CITY OF ALBUQUERQUE

November 30, 2017

**Re: Site Improvements 1218 Griegos
1218 Griegos Rd. NW
Traffic Circulation Layout
Architect's Stamp 11-22-17 (F14-D025)**

G-001

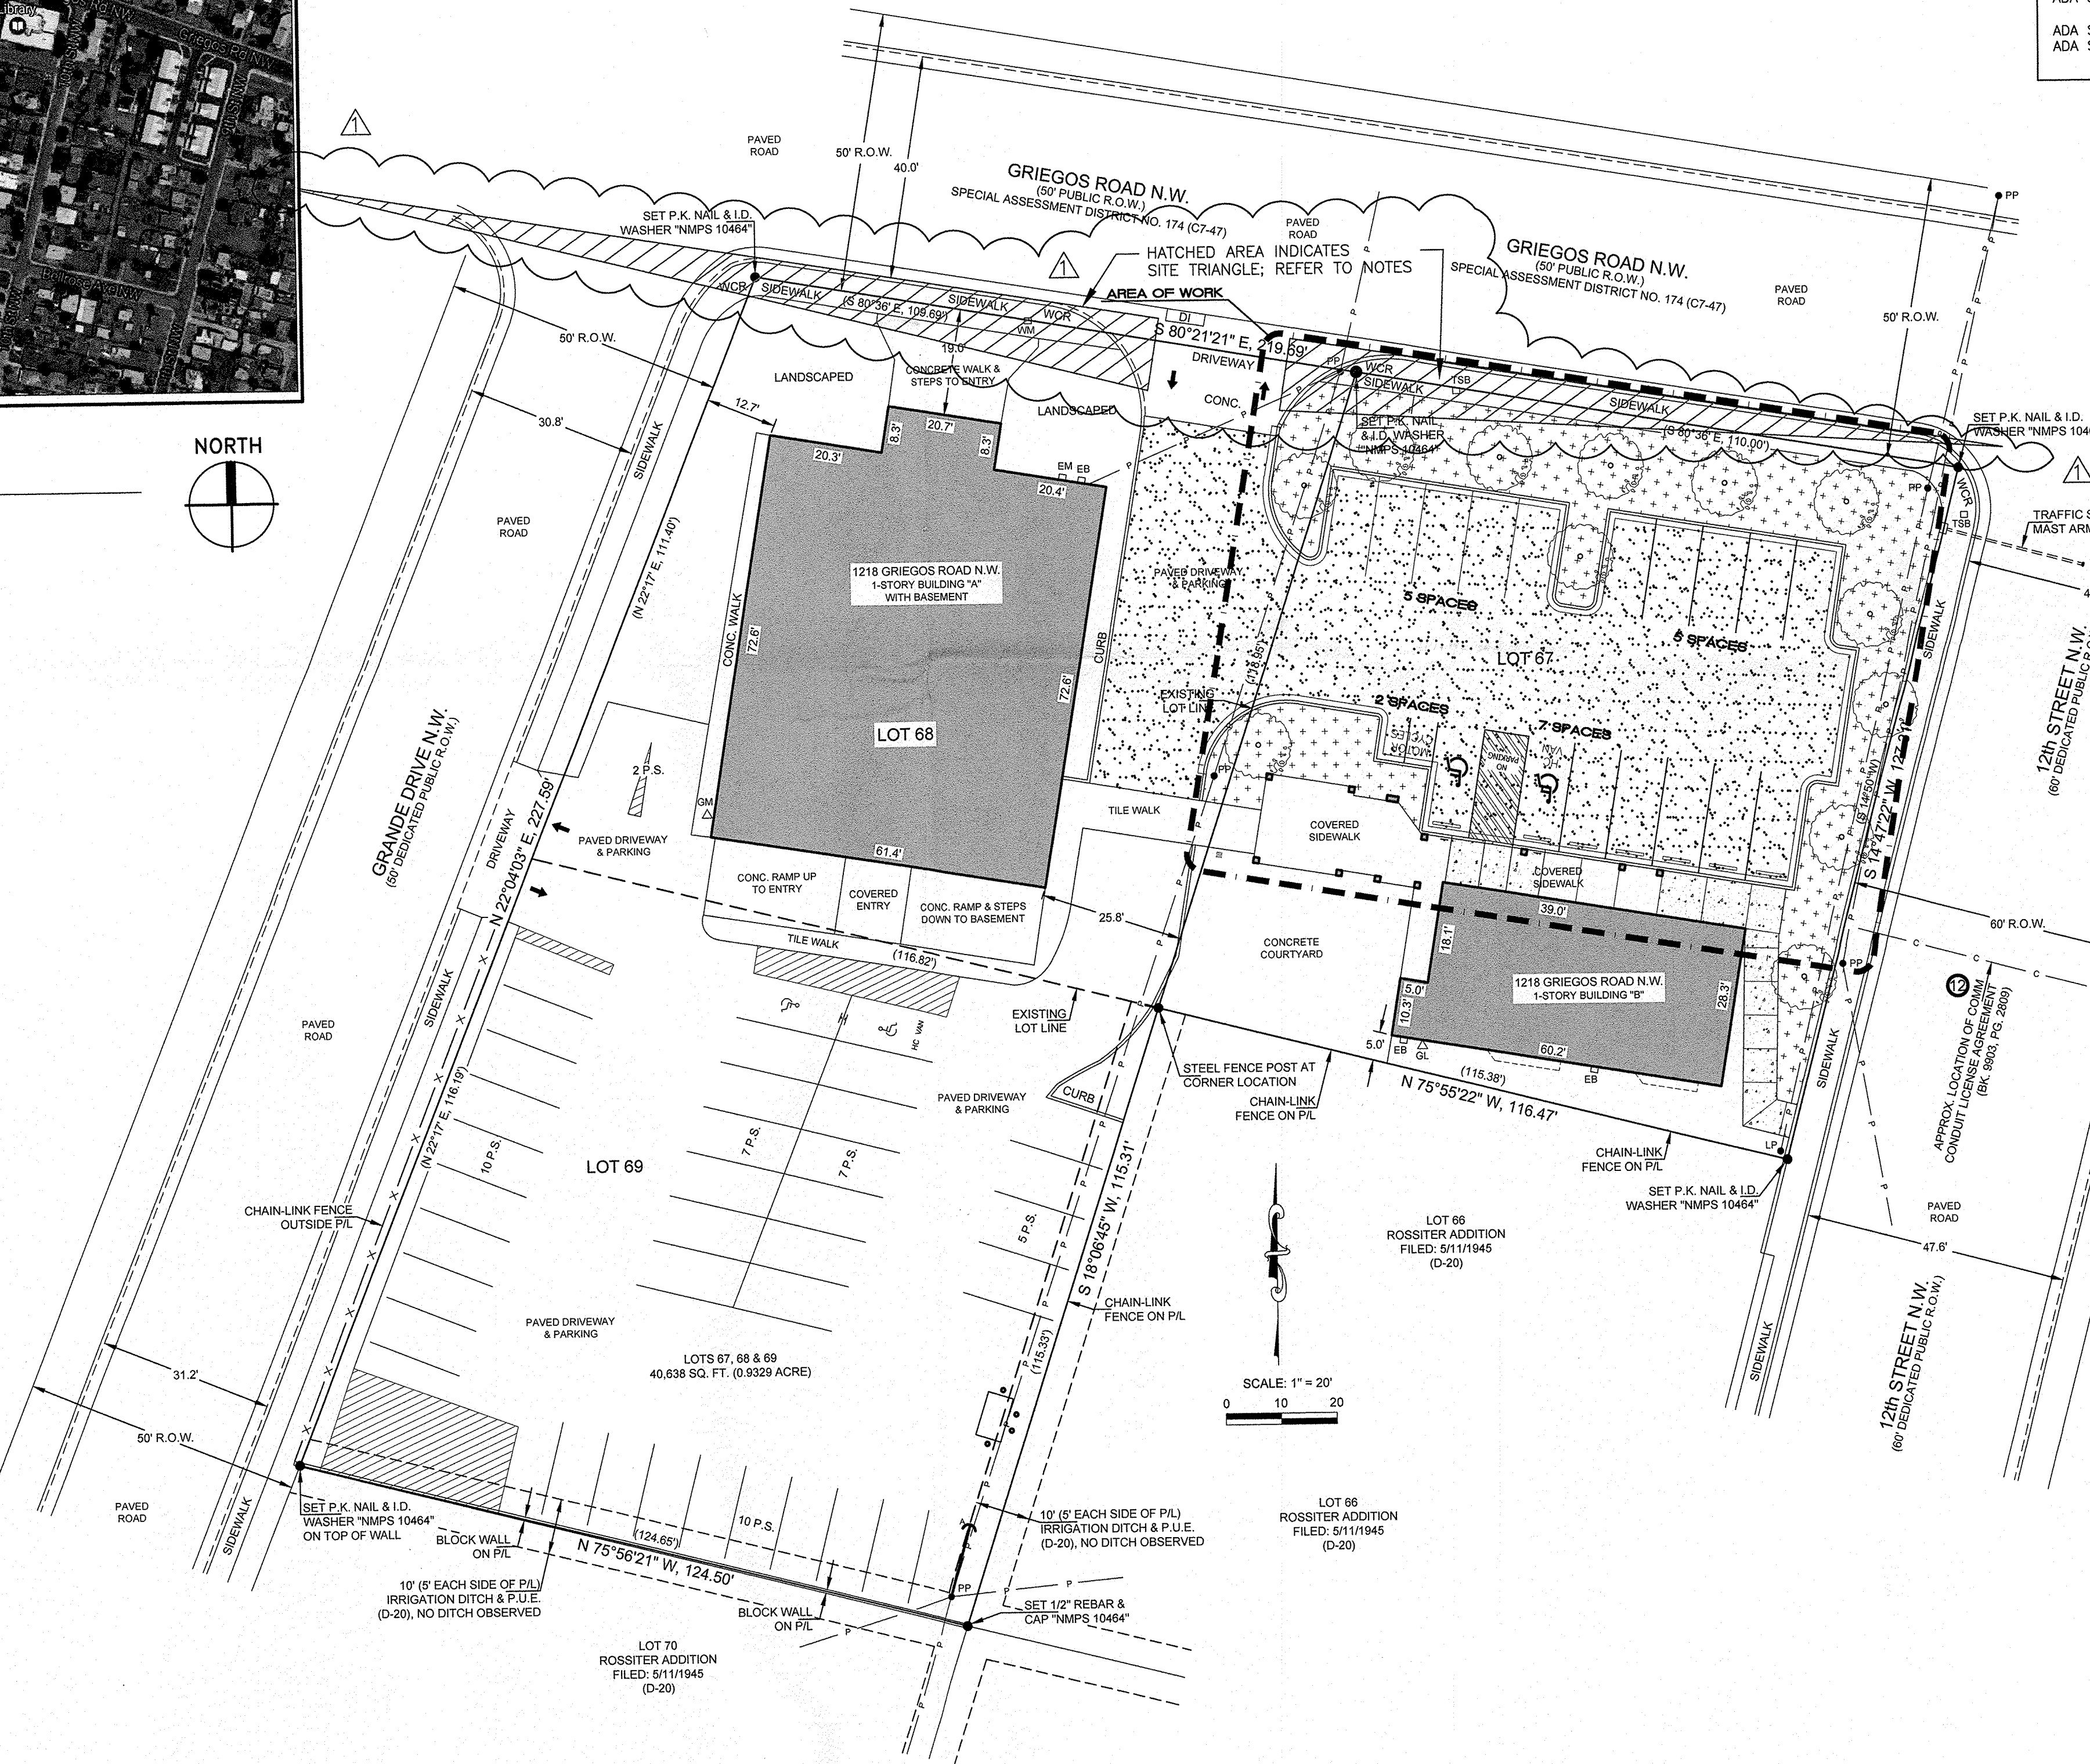
4. Show the clear sight triangle and add the following note to the plan:
"Landscaping and signage will not interfere with clear sight requirements. Therefore, signs, walls, trees, and shrubbery between 3 and 8 feet tall (as measured from the gutter pan) will not be acceptable in the clear sight triangle.

Sheet No.
AS101

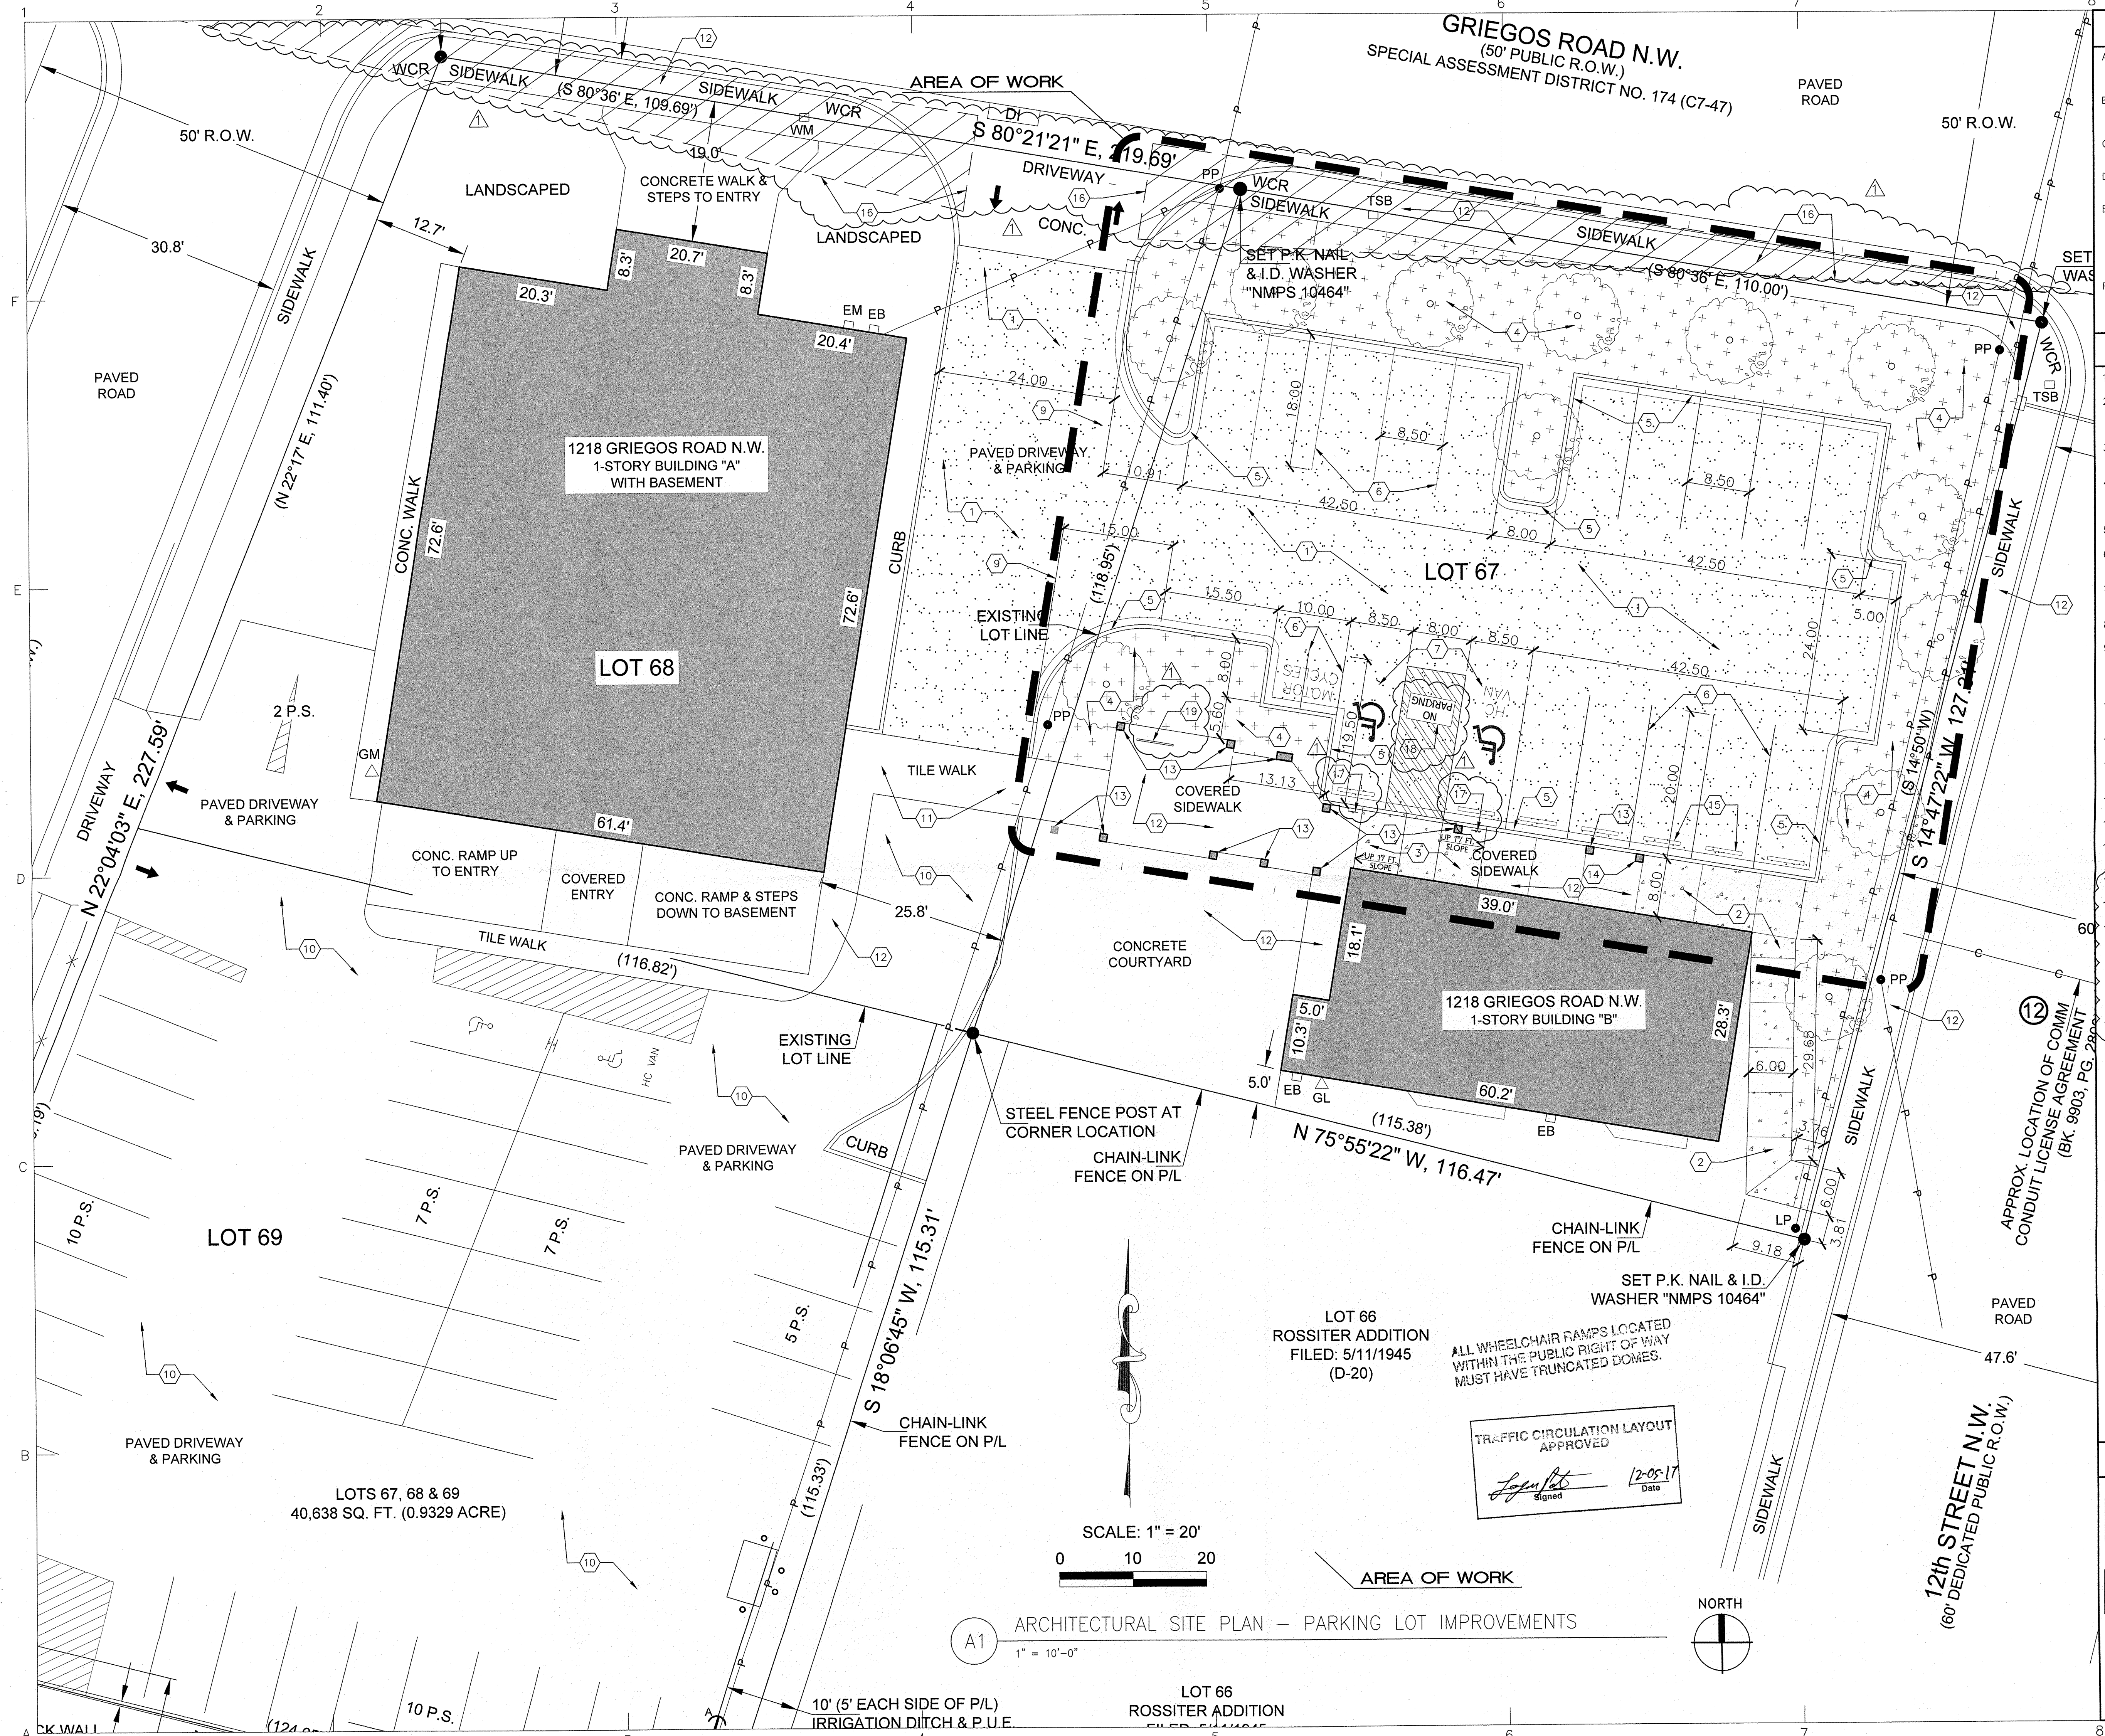
1. Show the location of the bicycle rack on the plan view.
2. The ADA accessible parking sign must have the required language per 66-7-352.4C NMSA 1978 **"Violators Are Subject to a Fine and/or Towing."** Please call out detail and location of HC signs.

3. The ADA access aisles shall have the words **"NO PARKING"** in capital letters, each of which shall be at least one foot high and at least two inches wide, placed at the rear of the parking space so as to be close to where an adjacent vehicle's rear tire would be placed. (66-1-4.1.B NMSA 1978)
